Attachment 1 Department of Planning, Industry and Environment Comments

Mamre Road Precinct

ALL FINISHED LEVELS SHOWN ARE $\pm 1000\text{mm}$

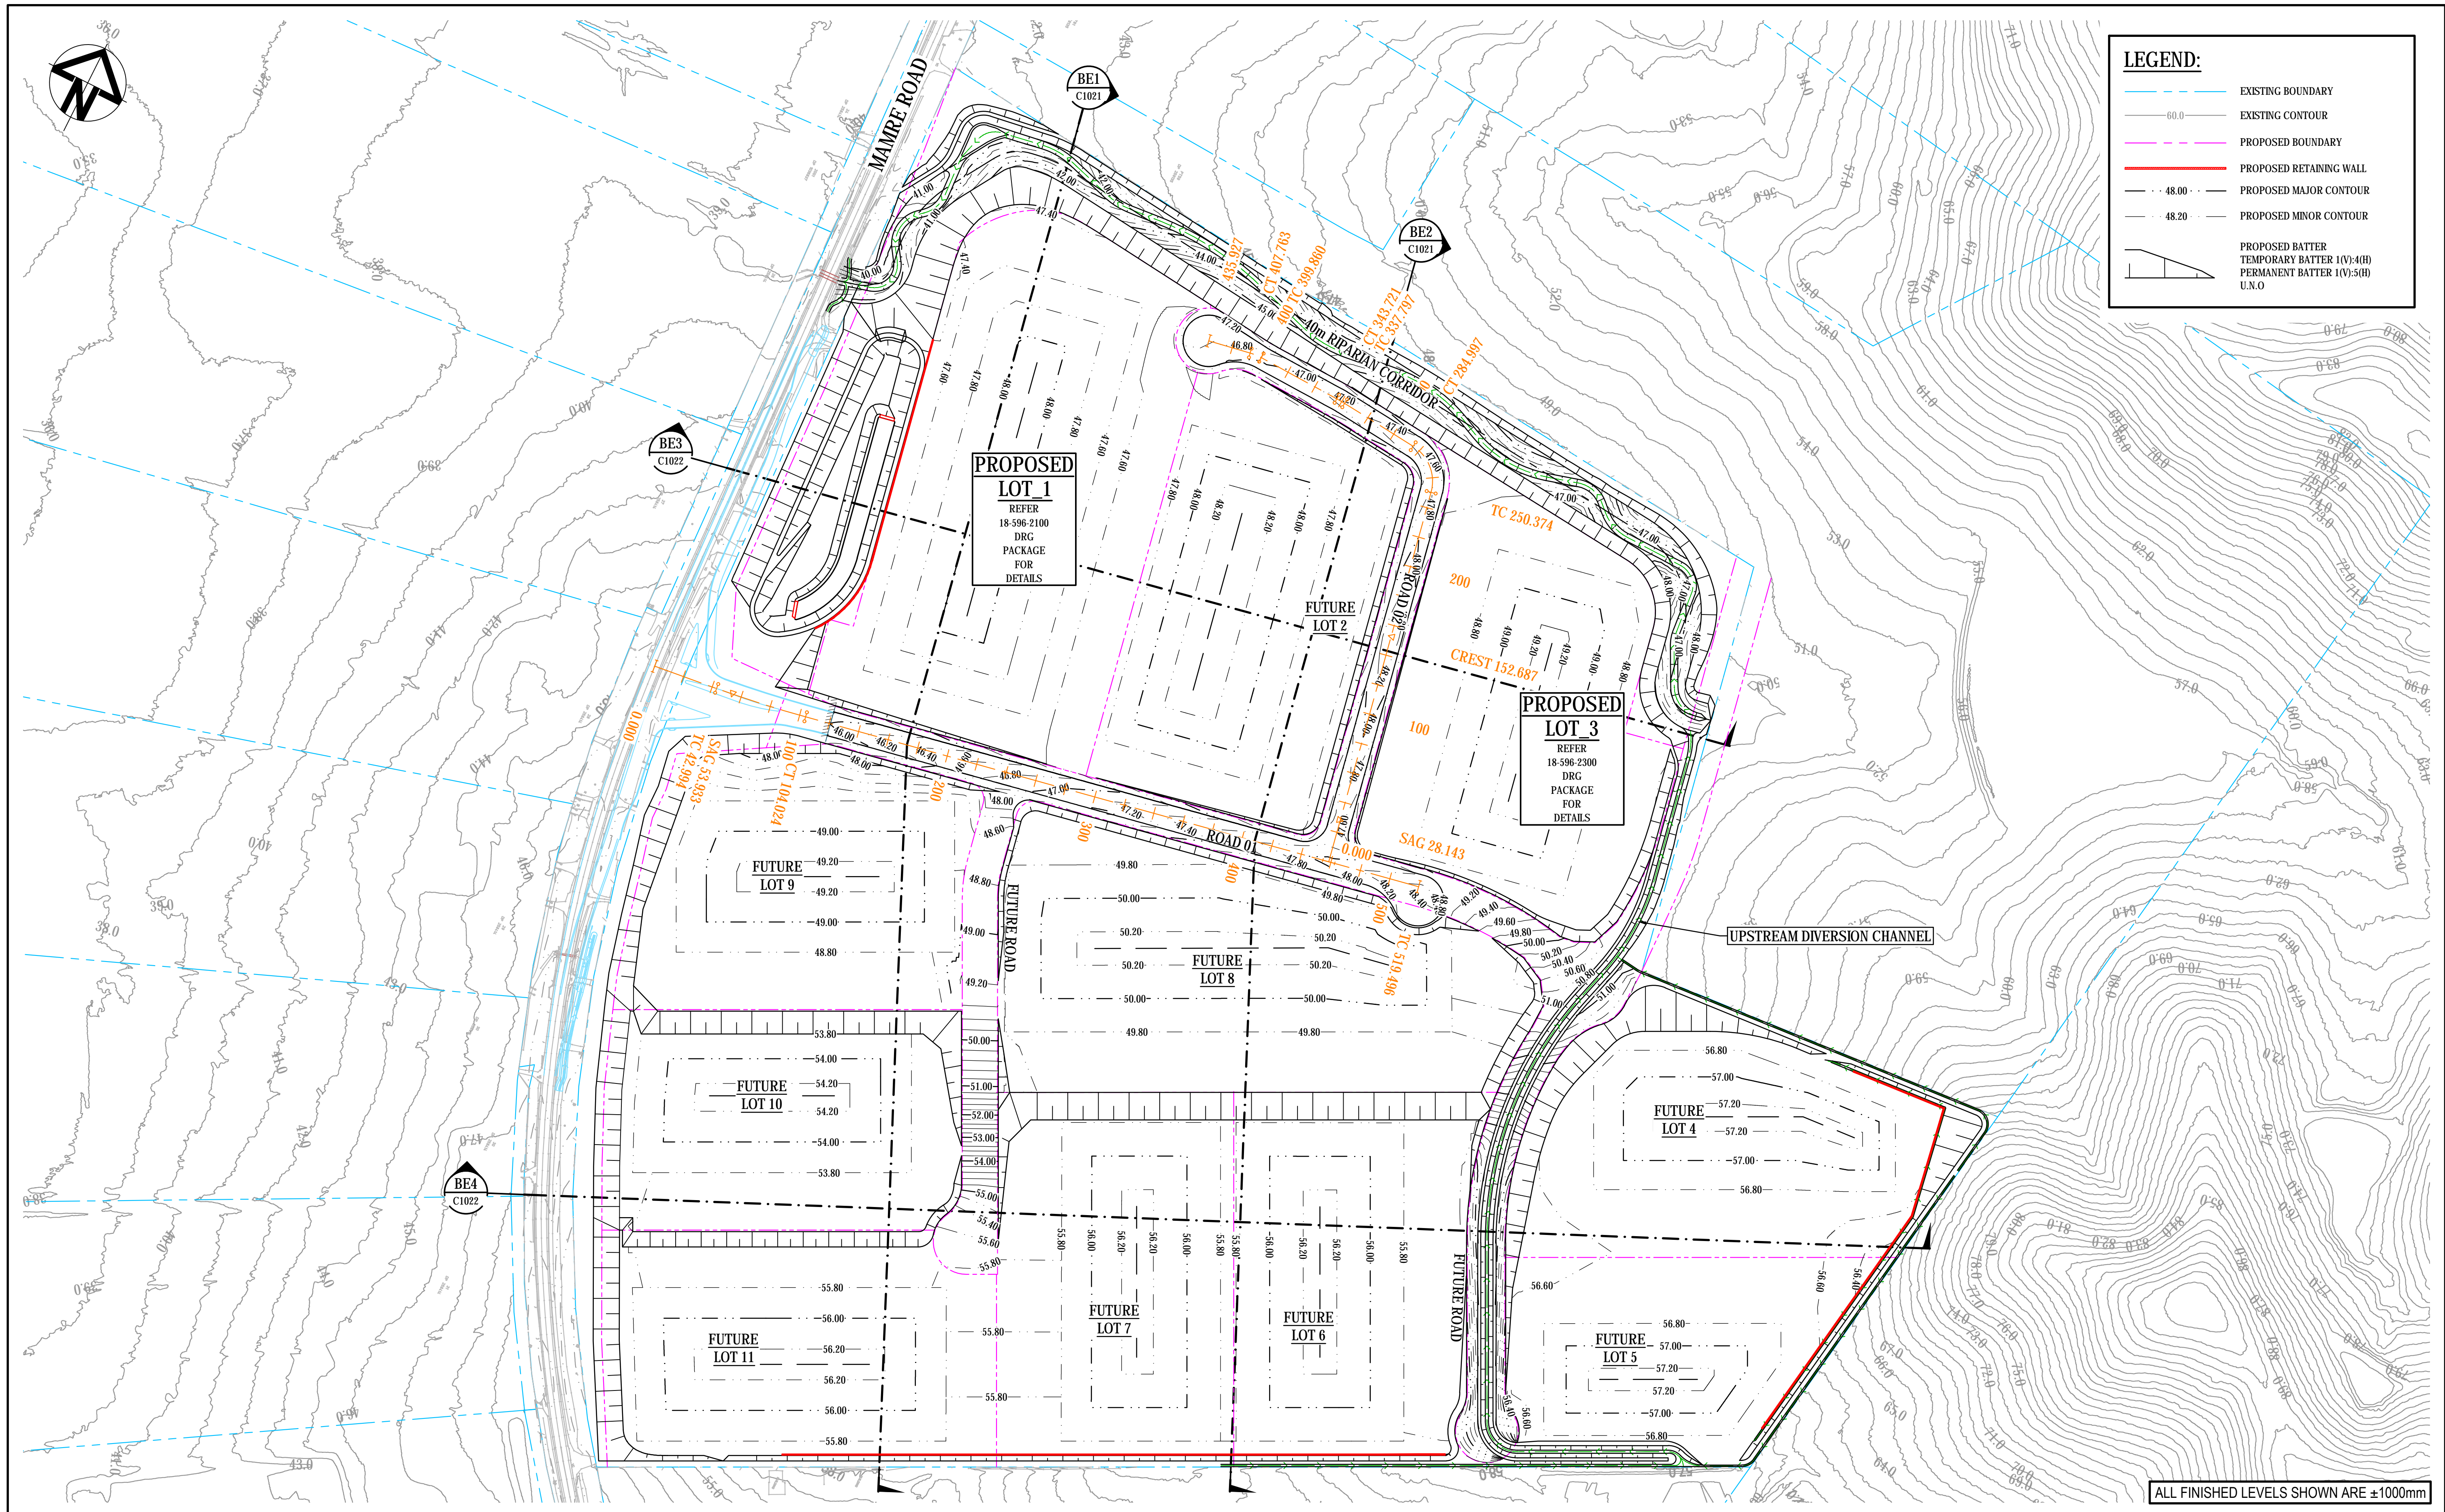
14. The Department notes the width of the proposed creek channel is inconsistent between documents. The Riparian Assessment Report states the channel would be 4.75 m wide, whereas Sections 1 and 2 in the Civil Drawing (No: 18-596-C1010) show the low-flow channel would be 5.6 m and 5.7 m wide respectively. Furthermore, the typical riparian corridor section in Civil Drawing (No: 18-596-C1006) shows a 3.75 m wide low-flow channel within a 20 m wide high flow channel. Please clarify the width of the channel.
